14 September 2011

**Major Project 11_0048 – Residential Development – Buildings 6, 9, 10 & 17
61 Mobbs Lane - Epping - Channel 7 Site (Epping Park)**

Plan View

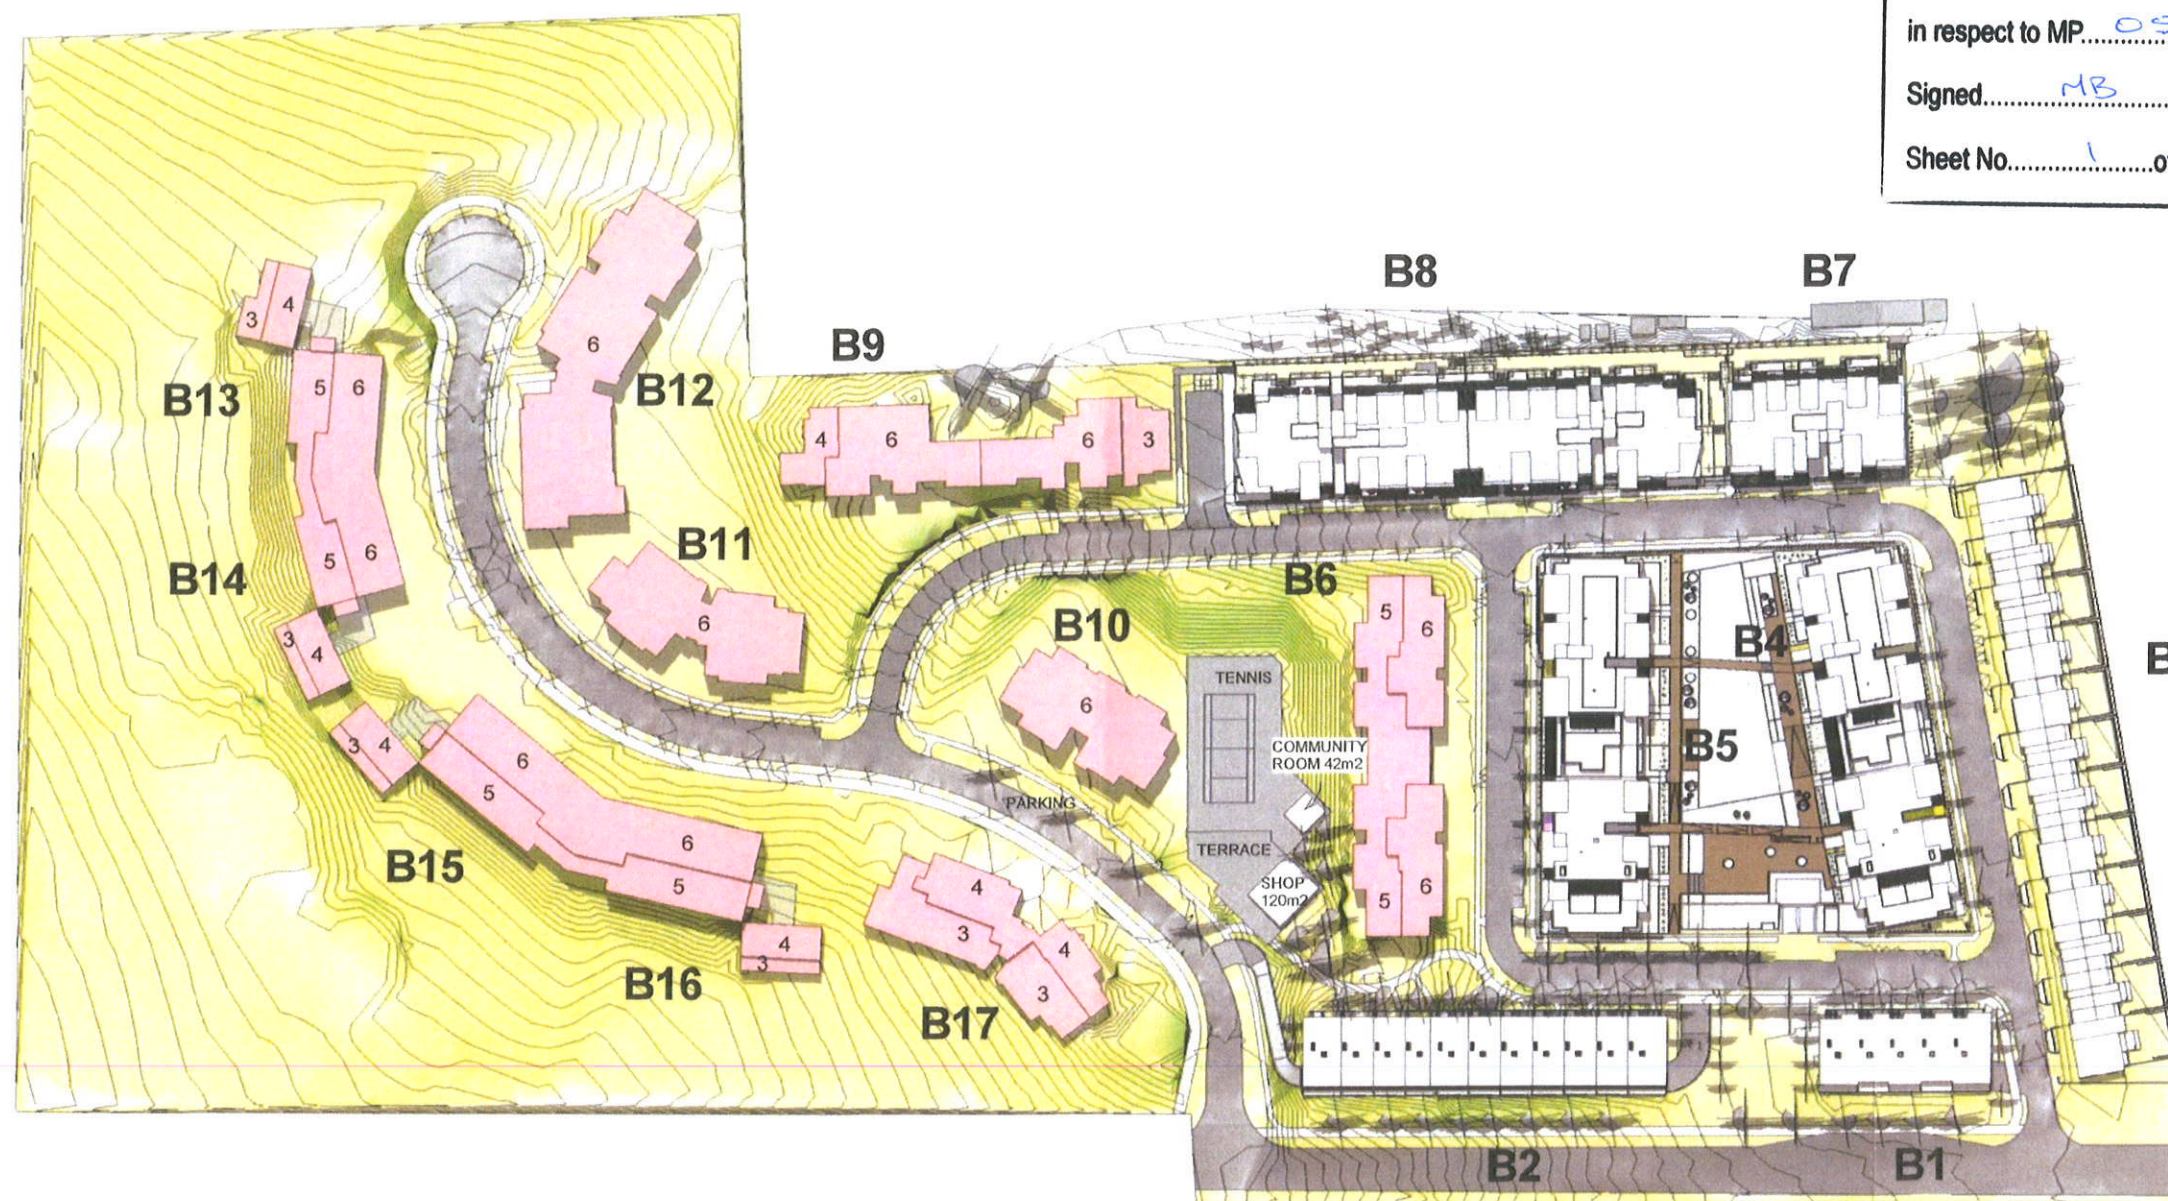
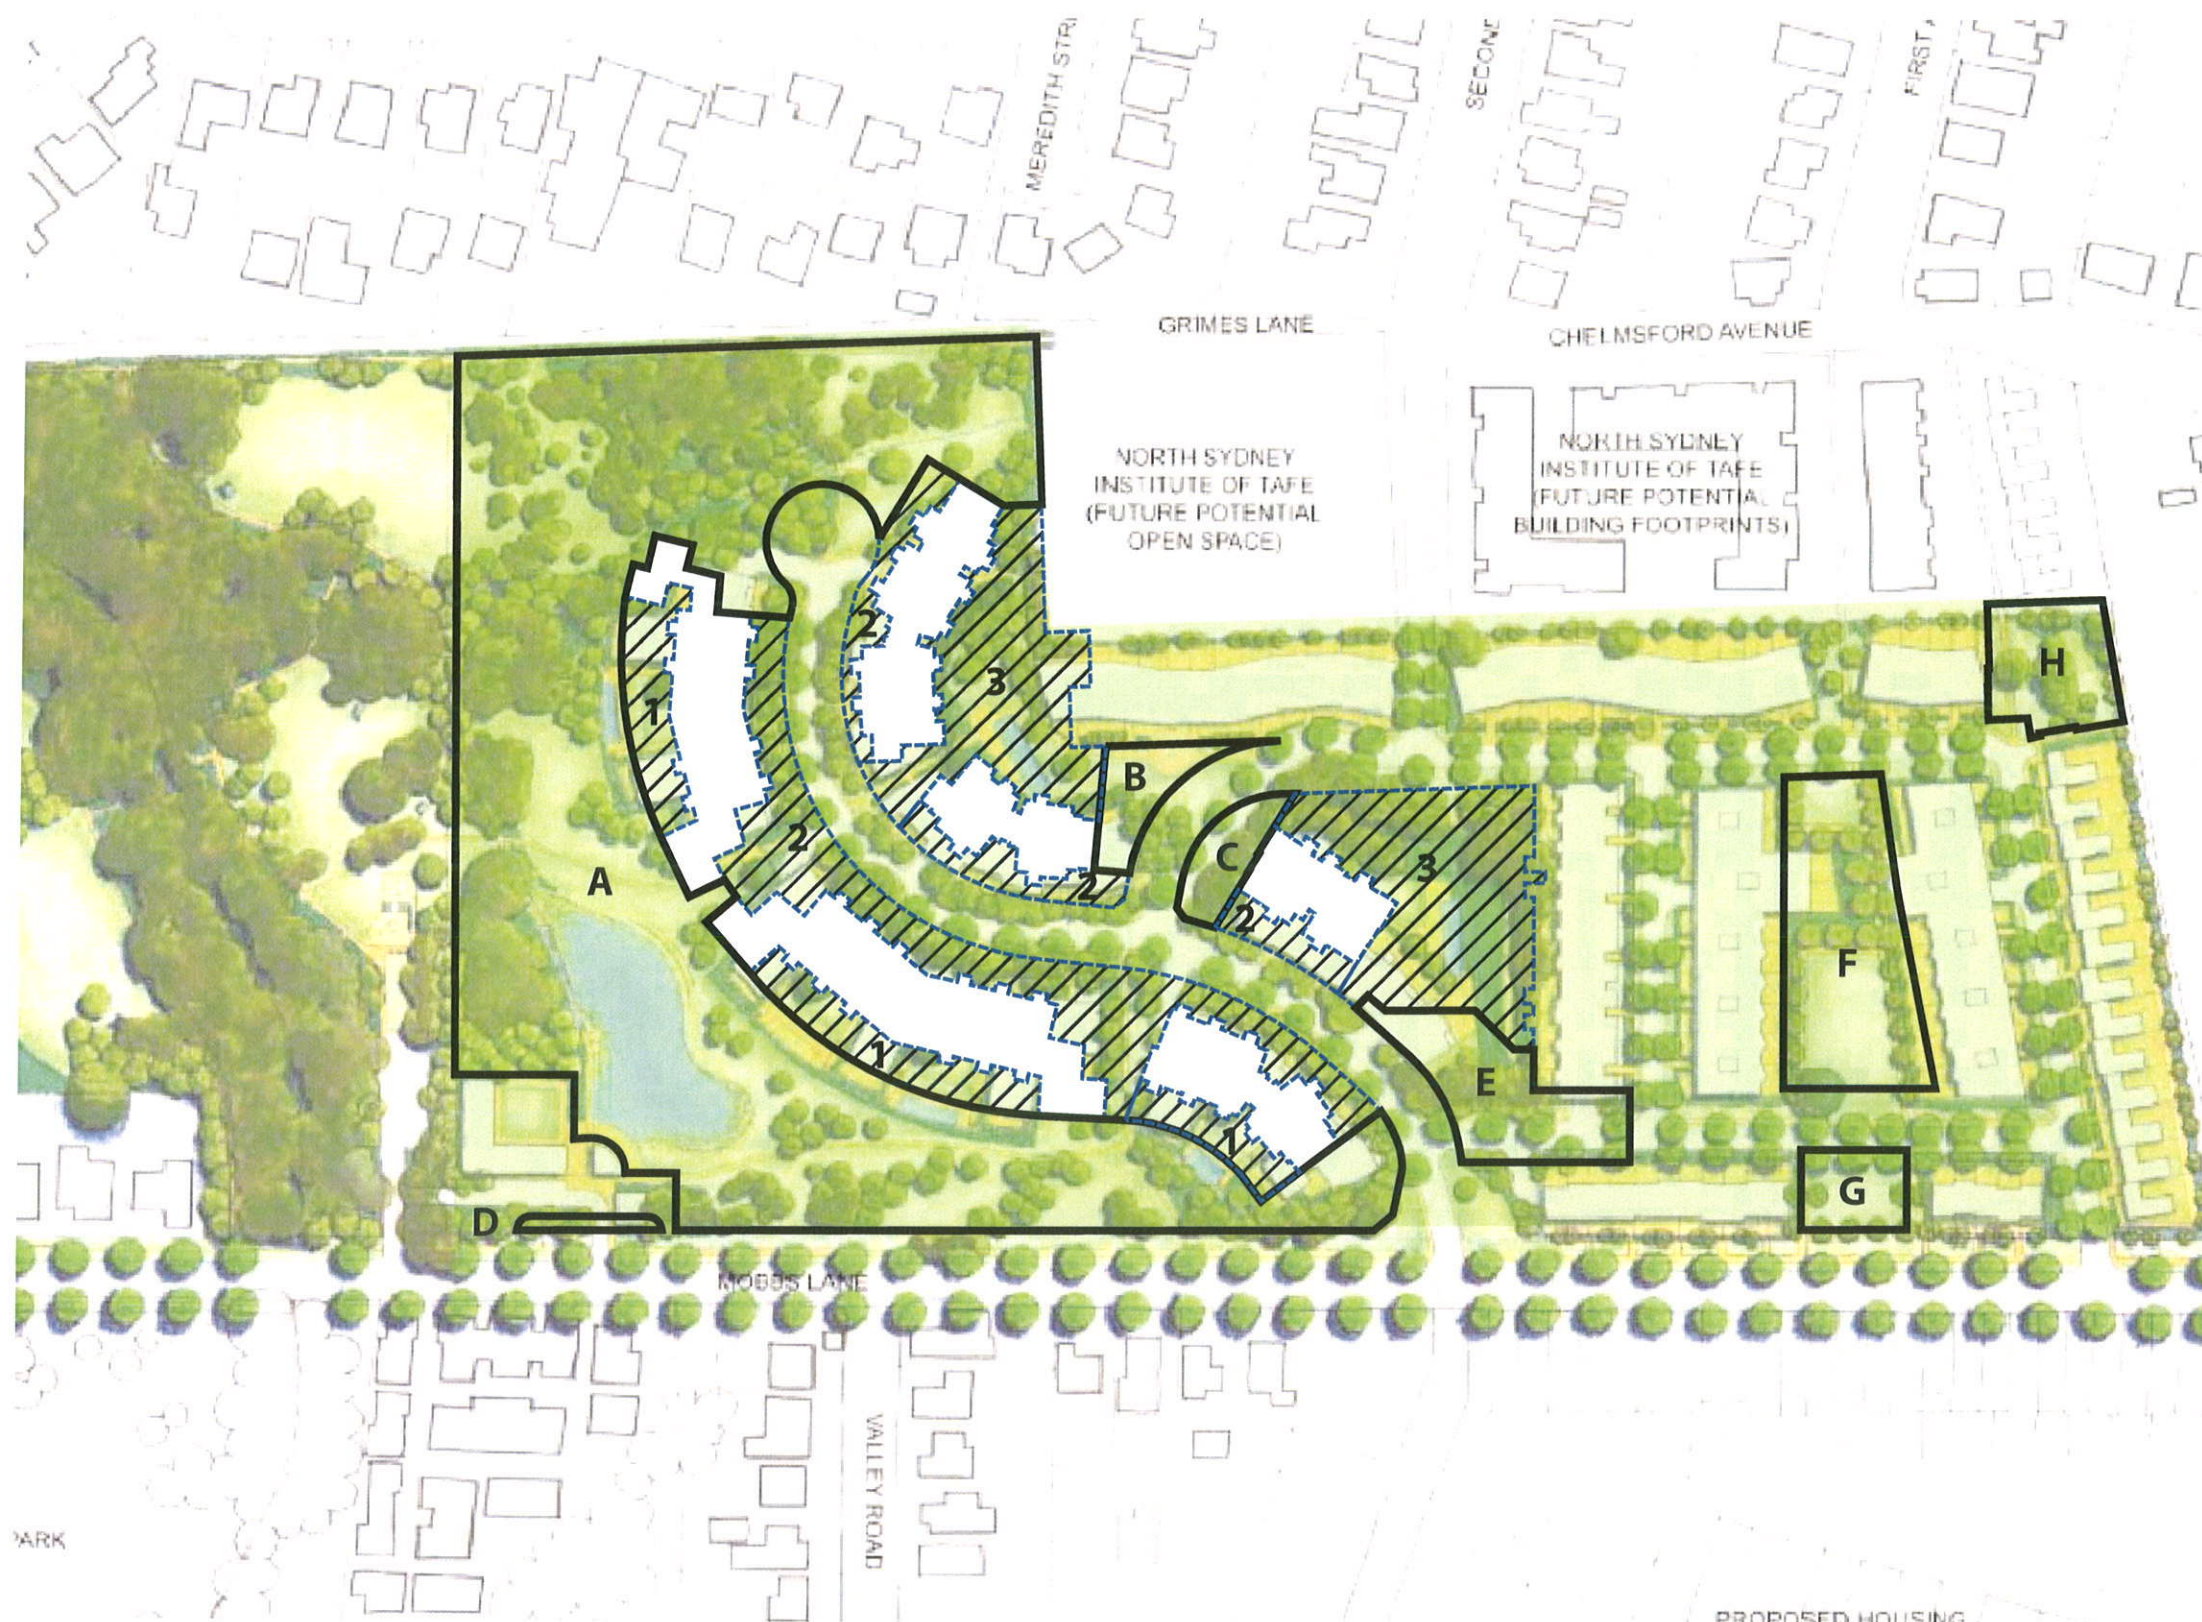
The approved height distribution of Building 6 indicates a 6 storey element on the northern elevation and a 5 storey element on the southern elevation. The plans submitted do not indicate the stepping of these storeys.

The approved height distribution of Building 9 indicates a 6 storey building with a 3 storey element to the north-east and a 4 storey element to the south-west. The plans submitted do not indicate the correct stepping of these storeys as the building is partially 5 storeys to the north-east and partially 6 storeys to the south-west.

The approved height distribution of Building 17 indicates 3 storeys facing the Mobbs Lane frontage with 4 storeys at the rear. The 3rd storey element is to wrap around to the west however appears as a 4 storey element on the submitted architectural plans.

1 SOUTH-WEST ELEVATION - BUILDING 6
1:100

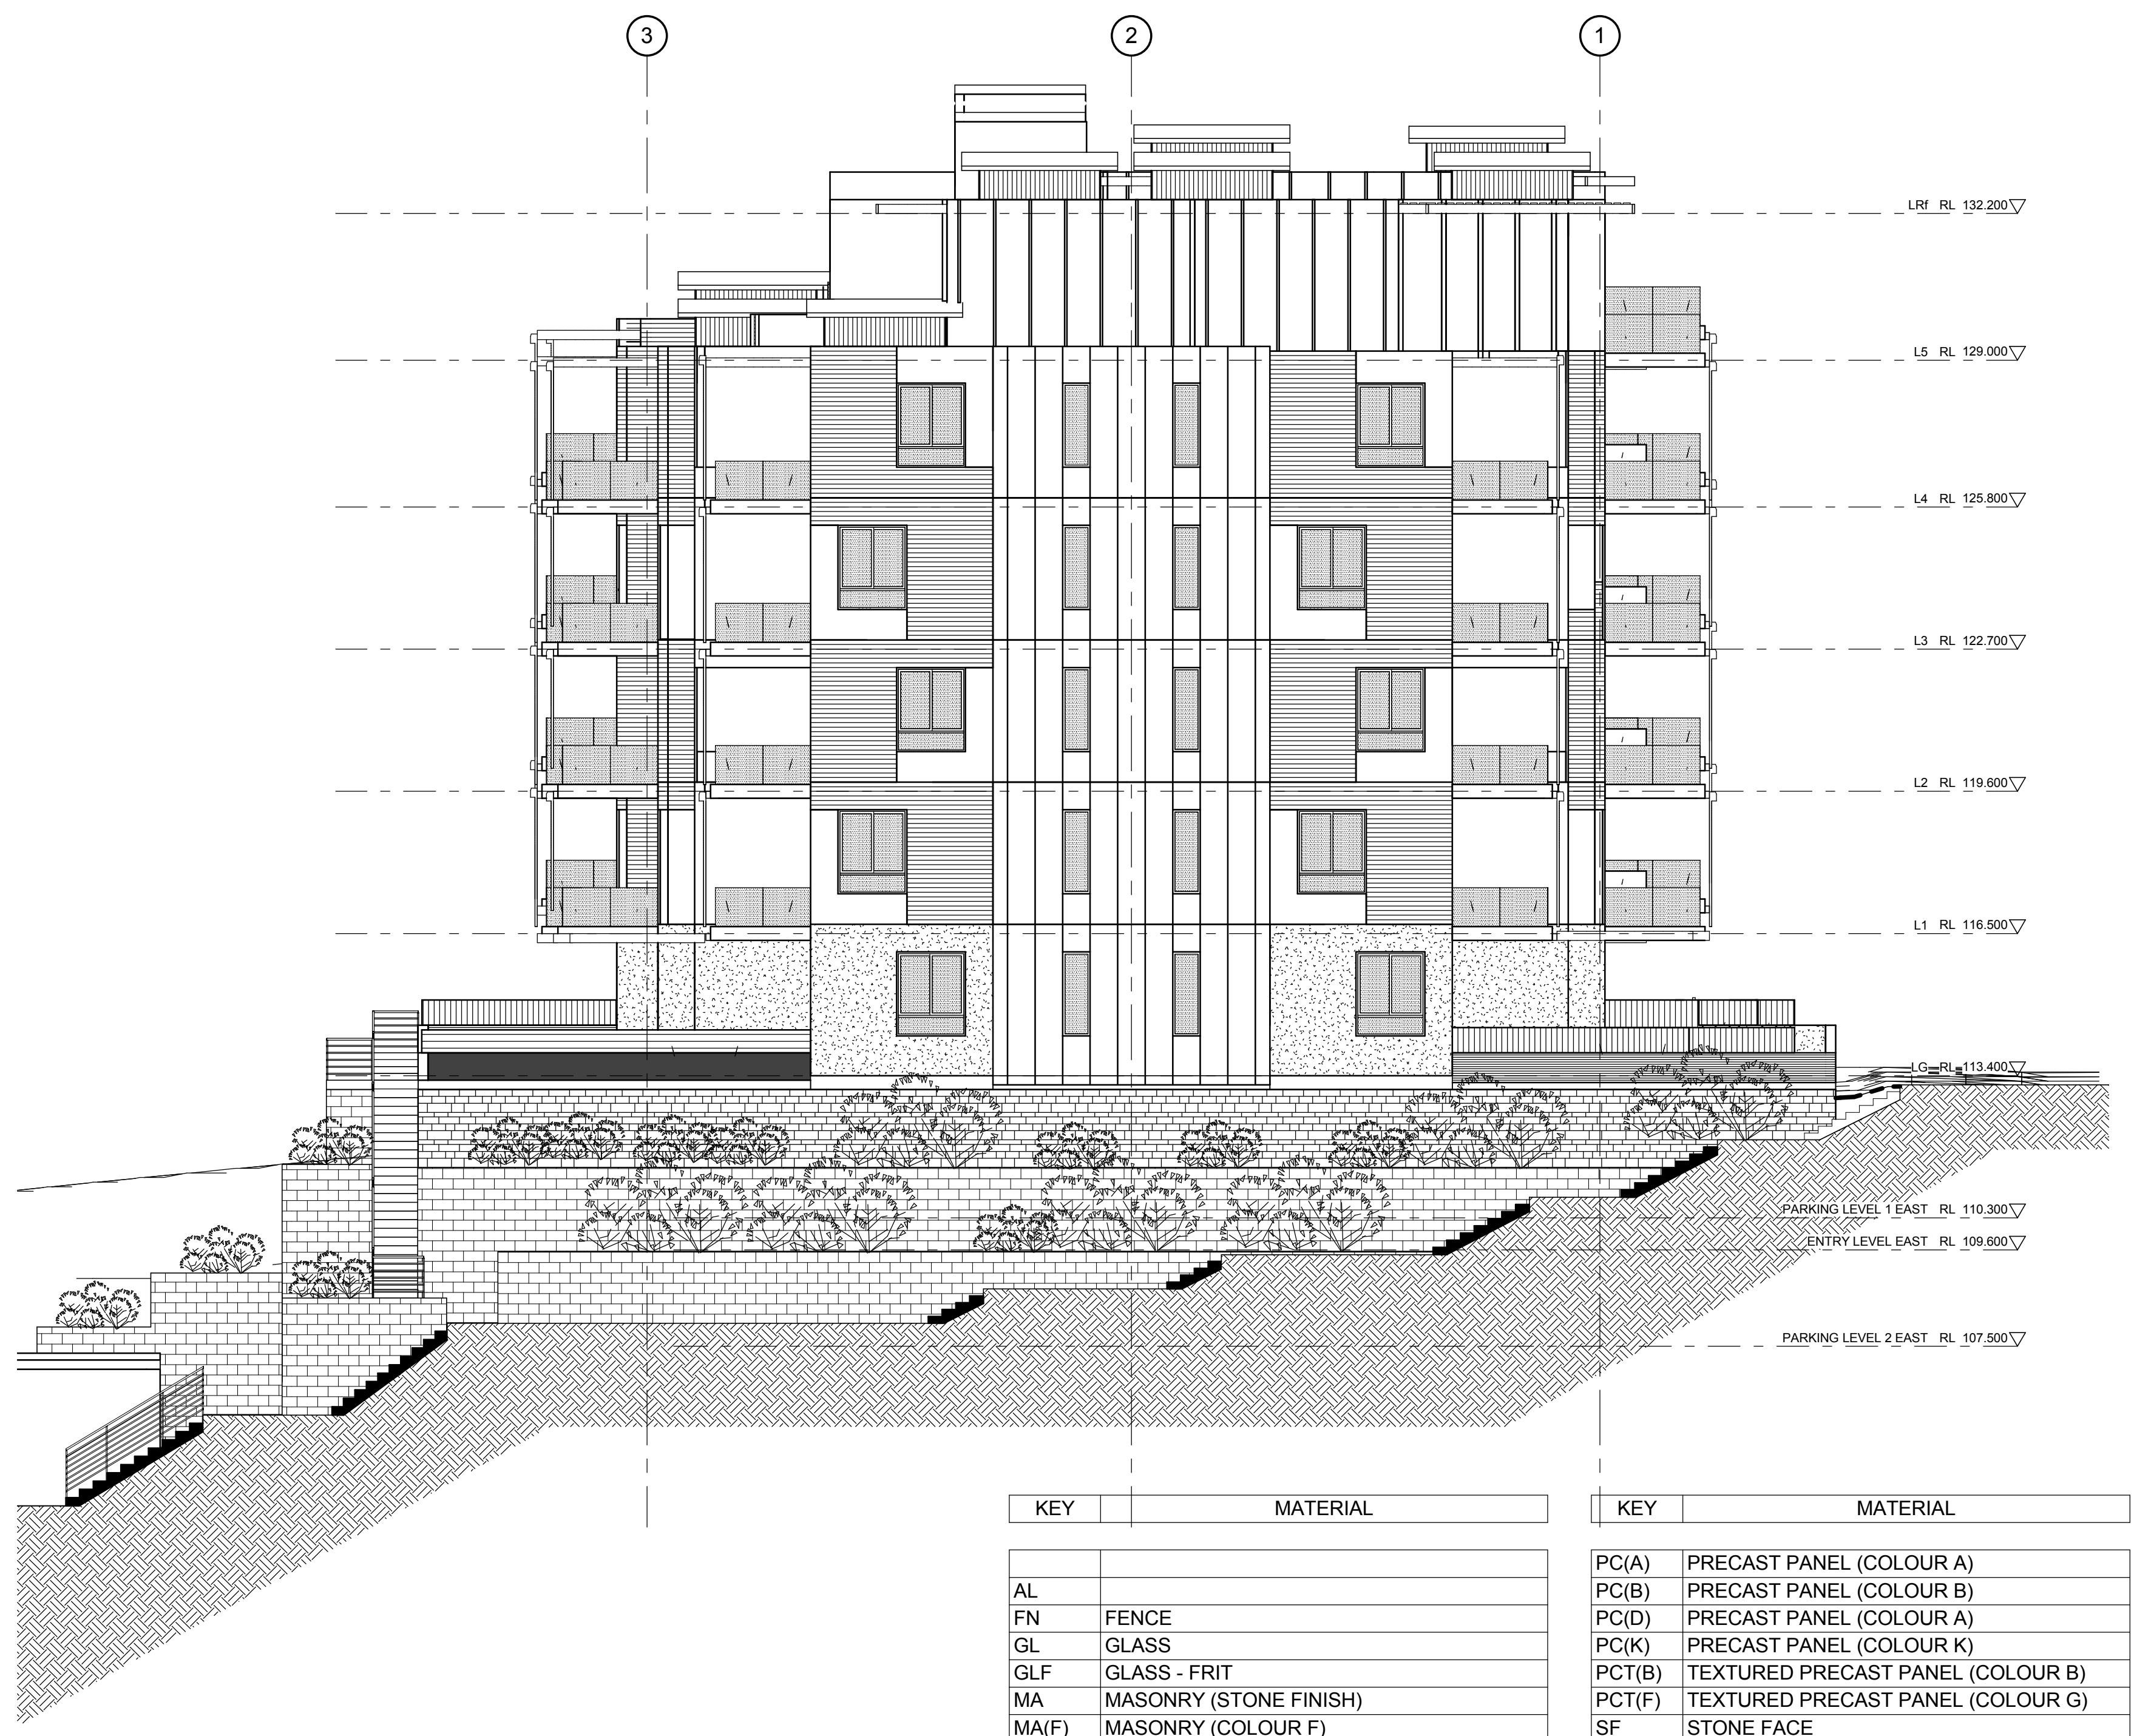
In addition, Section 1 (Drawing No. A0630 Rev E) and the south-western elevation (Drawing No. A0620 Rev E) both indicate that the building is 7 storeys in height. This appears to include the pool and gymnasium (Parking Level 1) and the 6 levels of residential located above.

This proposed height does not comply with the approved modified Concept Plan.
